Hampshire 2050
The Castle
Winchester, Hampshire SO23 8UL
Telephone 0300 555 1375
Fax 01962 847055
www.hants.gov.uk

Enquiries to	Holly Drury	My reference	6/3/6/445 (048965)
Direct Line	[REDACTED]	Your reference	58788/002
Date	25 April 2023	Email	[REDACTED]@hants.gov.uk

Application by AQUIND Limited (“the Applicant”) for an Order granting Development Consent for the proposed AQUIND Interconnector (“the AQUIND Interconnector project”)

REQUEST FOR INFORMATION

TITLE: **BROADWAY LANE SITE ACCESS JUNCTION - OPTION B GENERAL ARRANGEMENT**

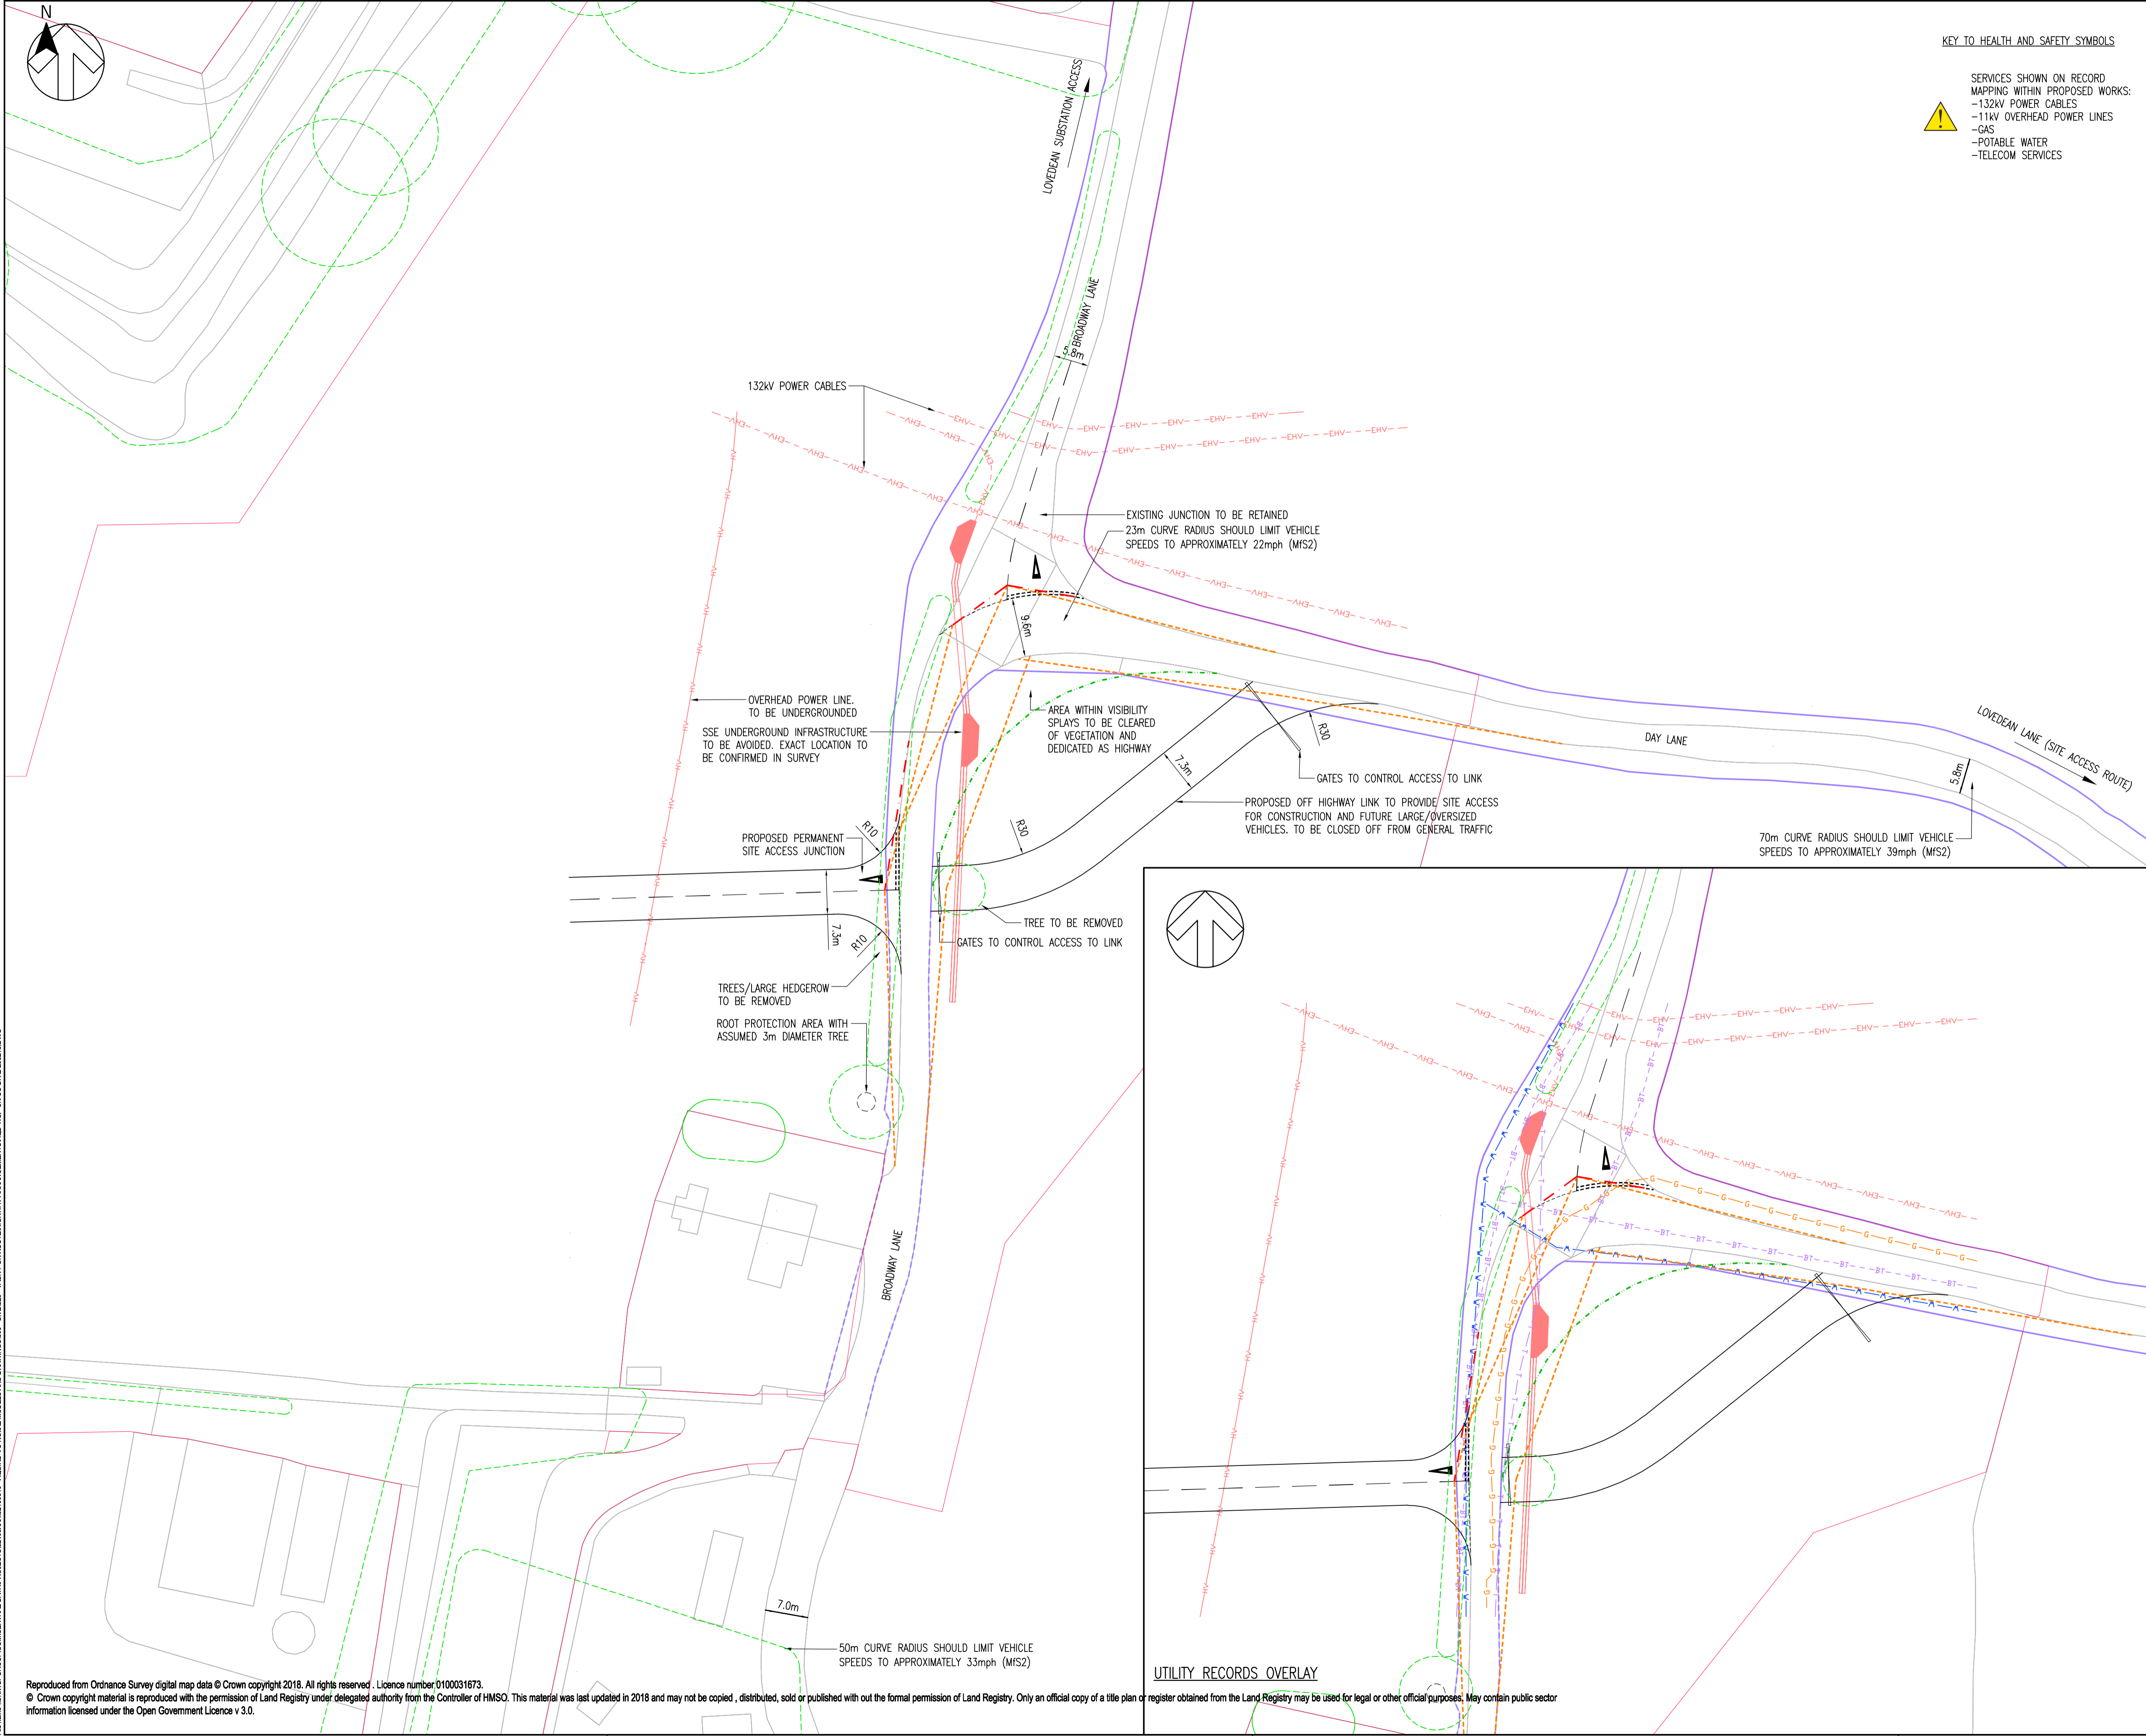
The Highway Authority is currently being consulted on the above application which is located on land surrounding the interconnector site for the Aquind development. The access arrangements and vehicle routing from the A3 are proposed along Day Lane and Broadway Lane with the construction access to the site being via an improved Broadway Farm access. A draft Construction Traffic Management Plan (CTMP) is in circulation which seeks to address construction concerns through a series of control parameters should the development come forward in isolation.

However, the Highway Authority wish to be satisfied that appropriate controls are put in place on any future permissions for either the Solar Farm application or the Aquind application to ensure that should there be an overlap in construction activities the offsite highway impacts are controlled appropriately.

The Aquind application team have proposed changes to the DCO drafting to bind them to a commitment to cooperate through a combined CTMP with the Solar Farm applicant in the event works overlap. This would see both developments construct within the agreed Aquind Parameters as set out in the Day Lane Technical Note Document Reference 7.9.28, PINS reference EN020022 dated 1 March 2021 and submitted at deadline 8 of the examination. This restricted total Day Lane vehicle movements to 71 two-way HGV movements a day and the methods of control to be in place to ensure the safe operation of the highway.

*(4) Notwithstanding anything contained in any approved construction traffic management plan, Work No. 2 (bb) (access junction and associated gated highway link) shall not be used for more than 71 two-way HGV movements (142 in total) per day in connection with the construction of the authorised development landwards of MHWS, **and including construction traffic associated with the Solar Development where the construction of the authorised development landwards of MHWS is concurrent with the construction of the Solar Development.***

The Highway Authority is satisfied that this addresses the concern in relation to any Development Consent Order granted to Aquind. Similarly, such conditions for compliance with a CTMP which agrees to appropriate coordination with the Aquind project being placed on the Solar Farm application would award appropriate controls to be in place for enforcing compliance by both parties, should the construction projects overlap.
